September 24, 2008

Kari Braniff
Community Development Services

Thank you for the opportunity to comment on the DW Farms Short Plat (SP-08-00021). In order to meet the requirements set forth by Kittitas County Public Health's Environmental Health Division and Kittitas County Code Chapter 13, the following items must be submitted:

**DW FARMS SHORT PLAT**  
LOCATED IN SECTION 32, TOWNSHIP 18 NORTH, RANGE 20 EAST, W.M.  
KITTITAS COUNTY, WASHINGTON  
SP-

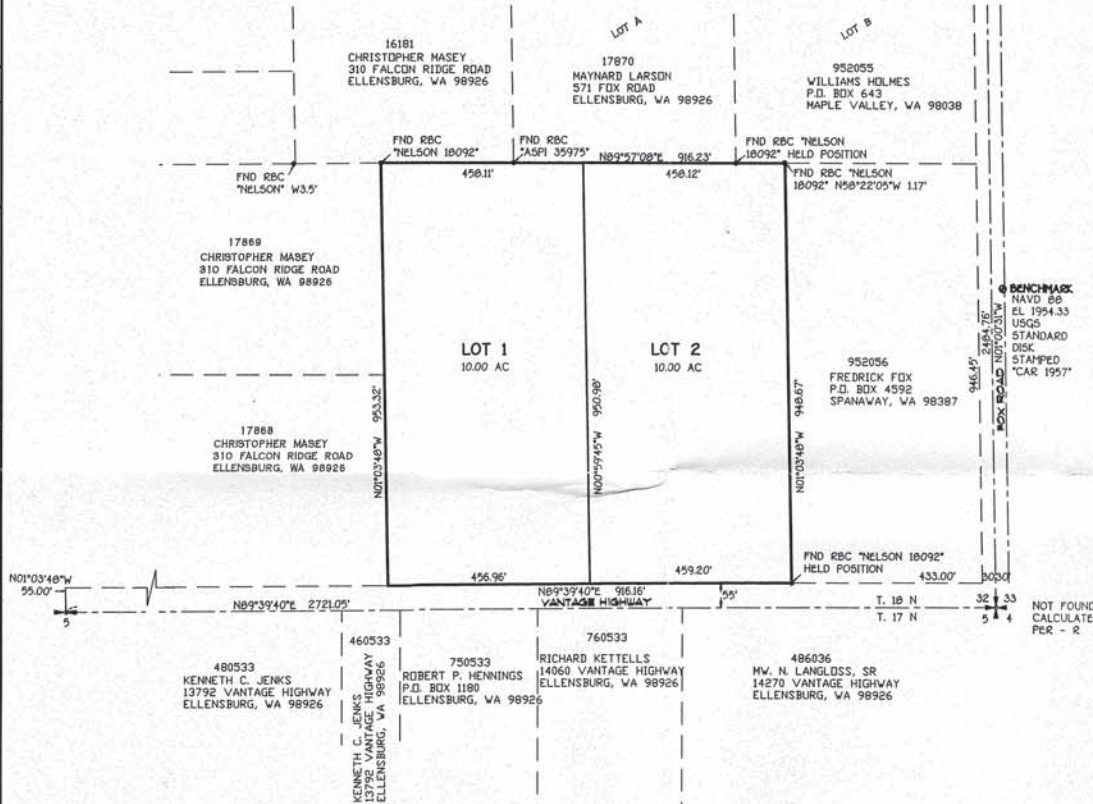
- Soil logs for each lot where installation of a septic system is intended;
- Well log for the existing well on the property, or a hydro geological report indicating water is available;

- *The following plat notes shall be included on the final mylar:*
 1. "The approval of this division of land includes no guarantee that there is a legal right to withdraw groundwater within the land division. The approval of this division of land provides no guarantee that use of water under the ground water exemption (RCW 90.44.050) for this plat or any portion thereof will not be subject to curtailment by the Department of Ecology or a court of law."

2. "The DW Farms Short Plat (SP-08-00021) currently has a total of 1250 gallons of water per day for all domestic and irrigation uses from the exemption. Each newly developed parcel will receive 625 gallons per day". Conditions of the original BMJ Short Plat (SP-02-05) on parcel 18-20-32000-0016 state, "The cumulative effect of water withdrawals for this development shall not exceed 5,000 gallons per day."

Note: if distribution of the available water between parcels is different than listed above, specify the quantity of water in gallons per day by parcel on the final mylar.

3. Kittitas County will require all new development county-wide to include water meters for each individual residential connection. Kittitas County Public Health's Environmental Health Program will choose the meter brand and design to be used and installed by professionals to meet the required specifications.
